CITY OF ALBUQUERQUE

April 17, 2015

Re: Sawmill Crossing Unit 2, Grading Certification-Final
Engineer's Stamp dated: 12-5-14, (H13D057)
Certification dated: 4-9-15

TITLE: *SAWMILL CROSSING - UNIT 2  
REVISED GRADING & DRAINAGE PLAN*

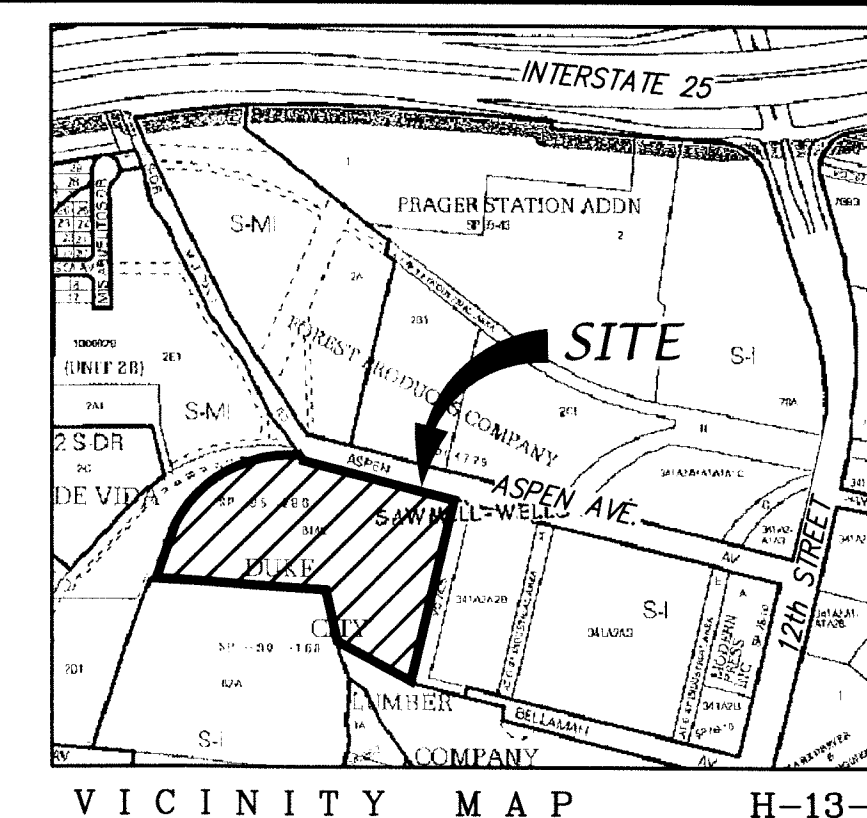
After a site visit and based upon the information provided in the Certification received 4-9-15, the above referenced certification is not acceptable to allow final building inspections/Certificates of Occupancy on lots in Unit 2. The curb and gutter has not been installed, nor the streets and there are no pads for lots 61-63,
